Development Control
Ribble Valley Borough Council

Re: Planning Application 18/0786

Address: Dog and Partridge Hesketh Lane Chipping PR3 2TH

Description: Conversion of an existing restaurant (A3) to create twelve apartments (C3) and the siting of four holiday lets.

# PROPOSED BLOCK PLAN

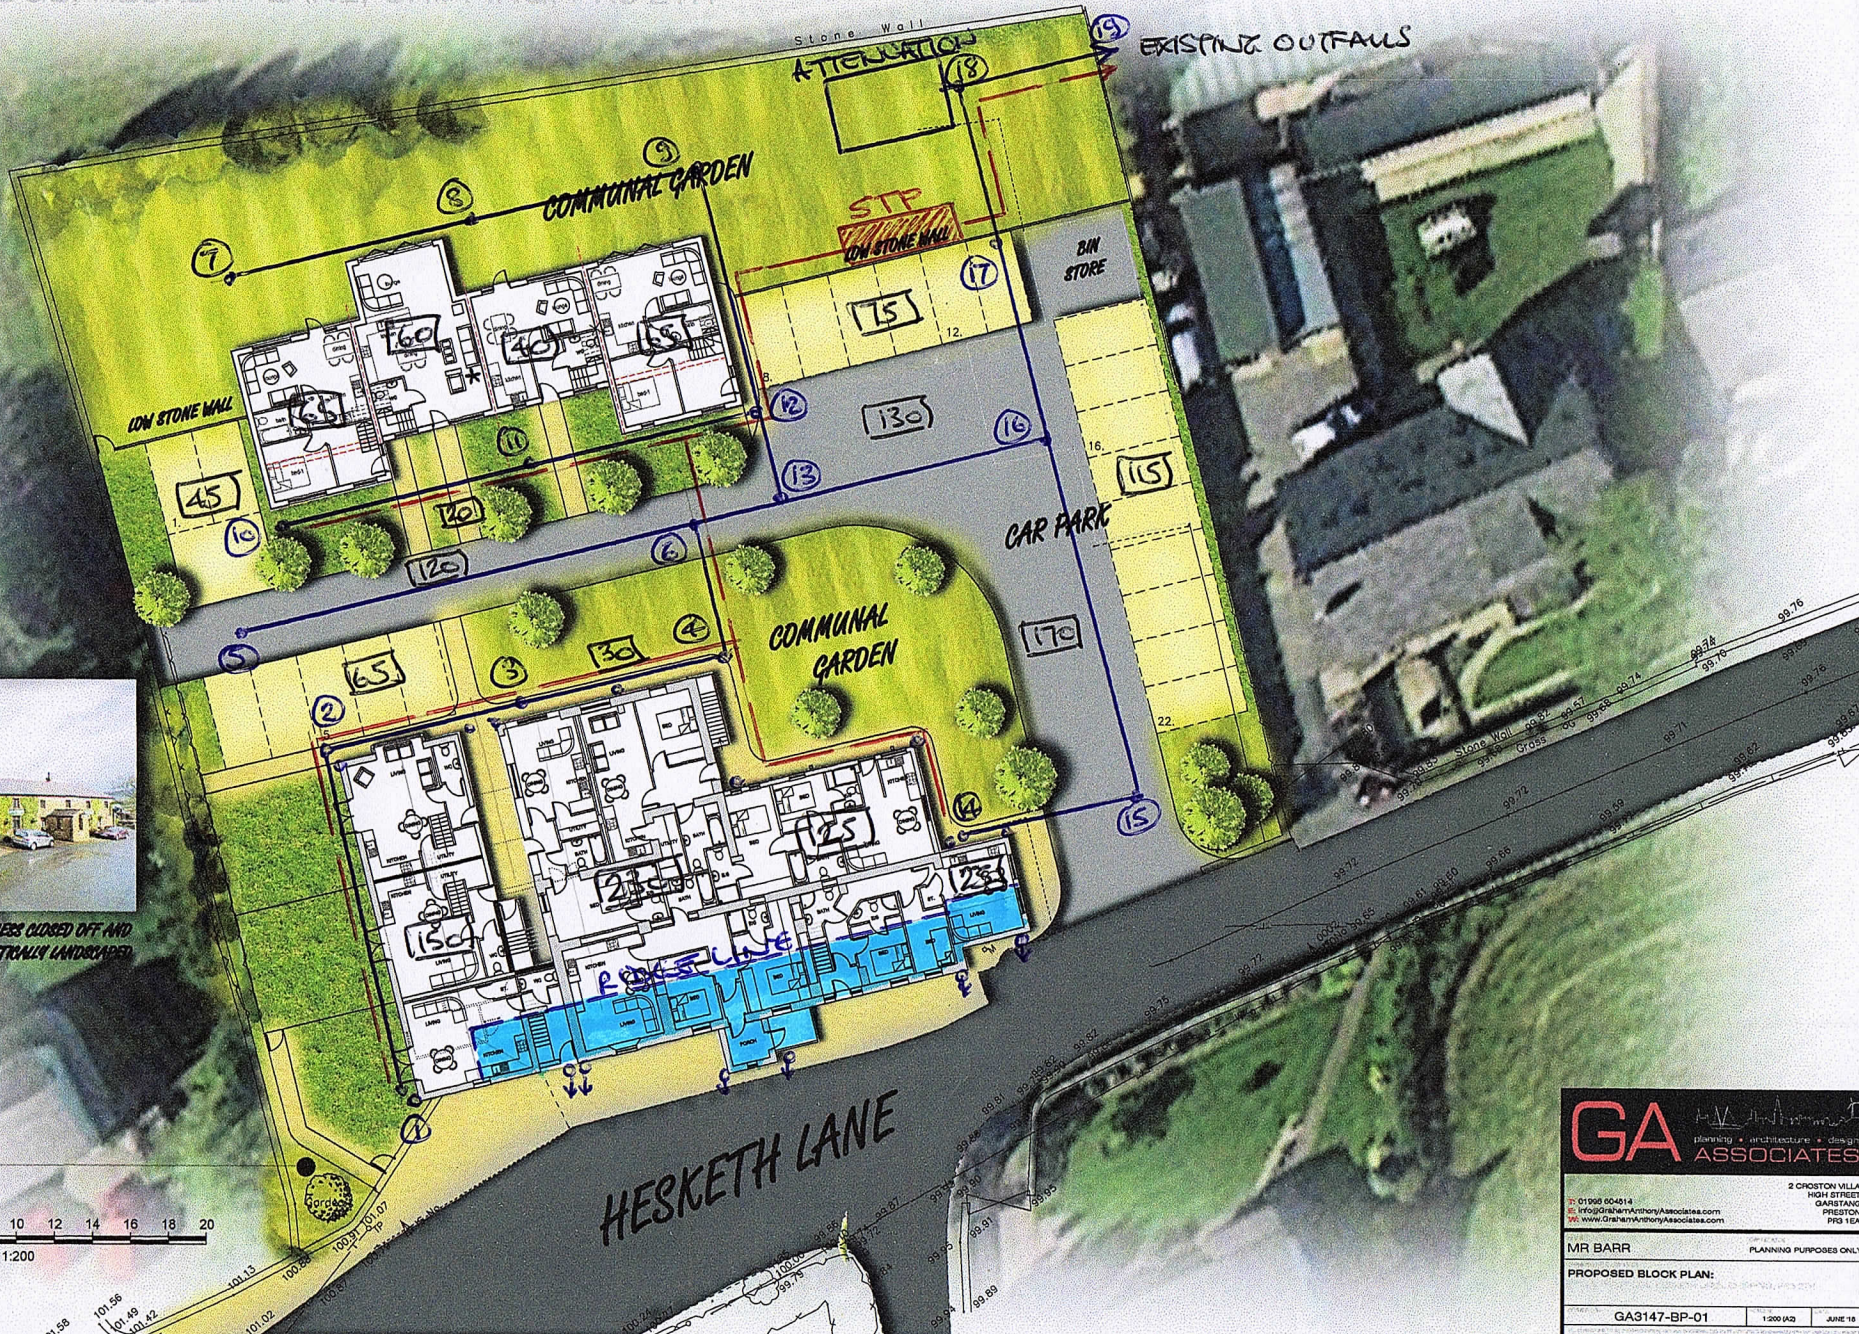
There are concerns regarding the pedestrian access along the frontage of the development from the car parking spaces to Apartments 3, 5, 6, 9 and 10. It is expected that a footway with a kerbed edge should be provided, partly to prevent additional parking which may lead to pedestrians having to walk in the carriageway.

A swept path analysis will be required to ensure that a refuse collection vehicle can enter and leave the site in a forward gear. Additionally the positioning of the bin storage point should be looked at, according to the Department of Transport's document Manual for Streets Section 6.8.9 states that residents should not be expected to carry waste more than 30m to the storage point. Similarly, refuse collection vehicles should be able to get within 25m of the storage point. It may be a requirement that there are a number of bin storage points, rather than one central location, with some flats being served from the roadside frontage of the development.

There appears to be no provision for any cycle storage, this applies to both the residential complex and the holiday lets. It would be expected that the holiday lets would have sufficient covered cycle storage for 4 cycles to each let, with additional covered cycle storage being provided for the residential complex.

It is expected that the site will be drained along Suds principles and merely just allowed to run off onto the adopted highway.
